Application No: BR/14/26/PL
Site Address: Bottom Flat 9 Stocker Road Bognor Regis PO21 2QH
Description of works: Proposed annexe to rear garden which is ancillary to the main dwelling. This application is in CIL Zone 4 and may be CIL liable.

OBJECTION

ELEVATIONS AS EXISTING 1:100 @ A4.

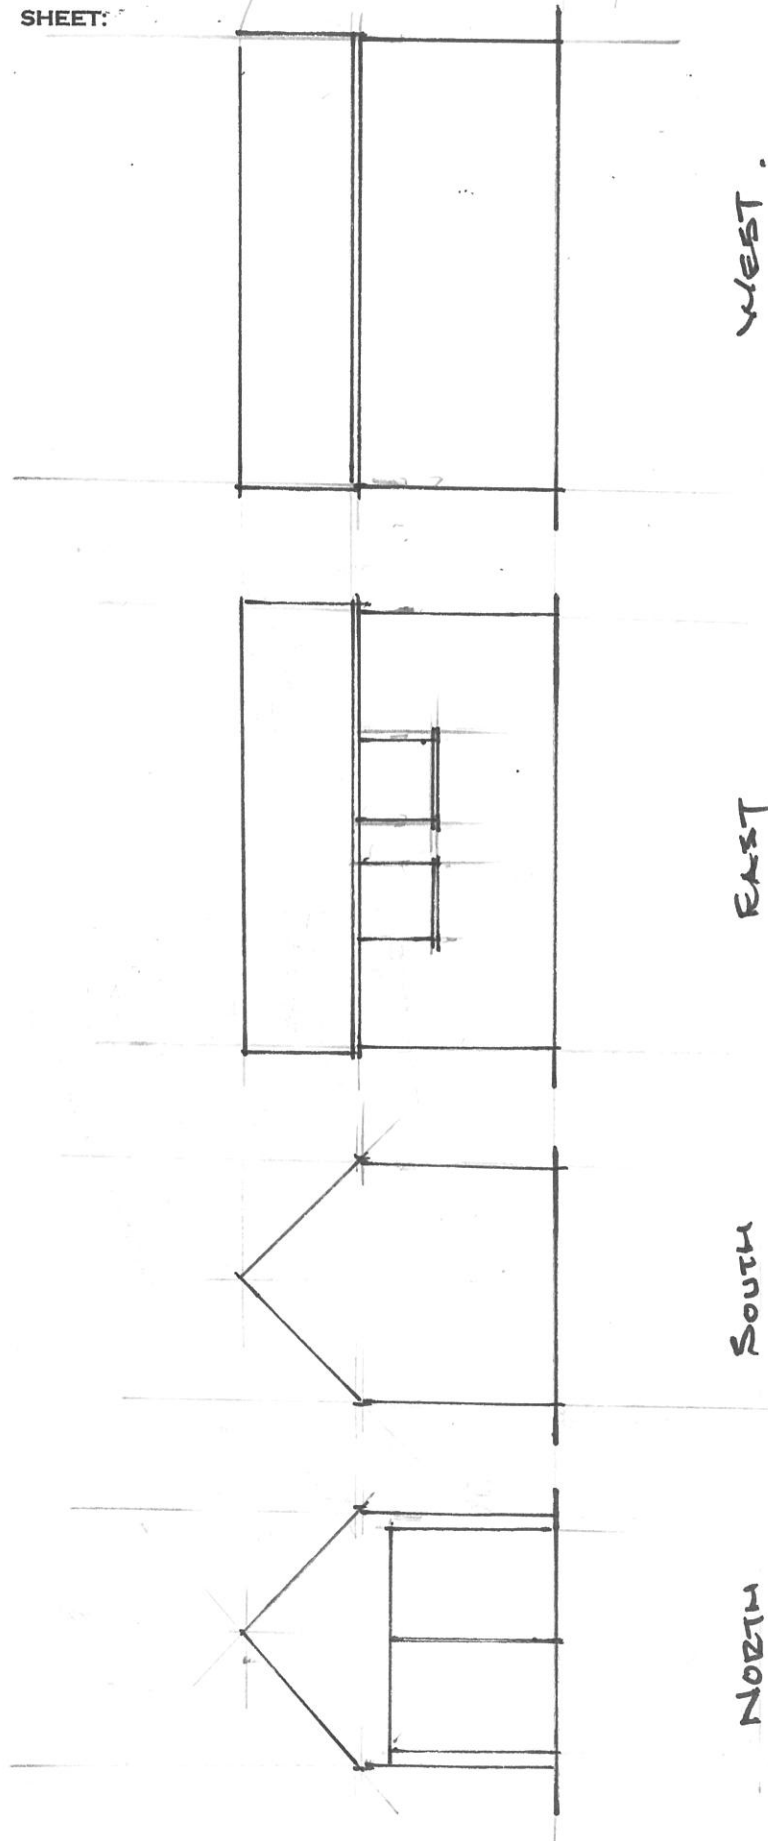
Insufficient information has been provided in relation to the orientation of windows, sight lines, and potential overlooking impacts on neighbouring properties.

Given the siting of the proposed annexe within the rear garden, there is a clear risk of direct overlooking into neighbouring gardens and rear-facing habitable rooms, resulting in a loss of privacy.

The application does not provide sufficient detail regarding design, scale, height, or the positioning of openings to enable a full and proper assessment of its impact on neighbouring properties and the surrounding area.
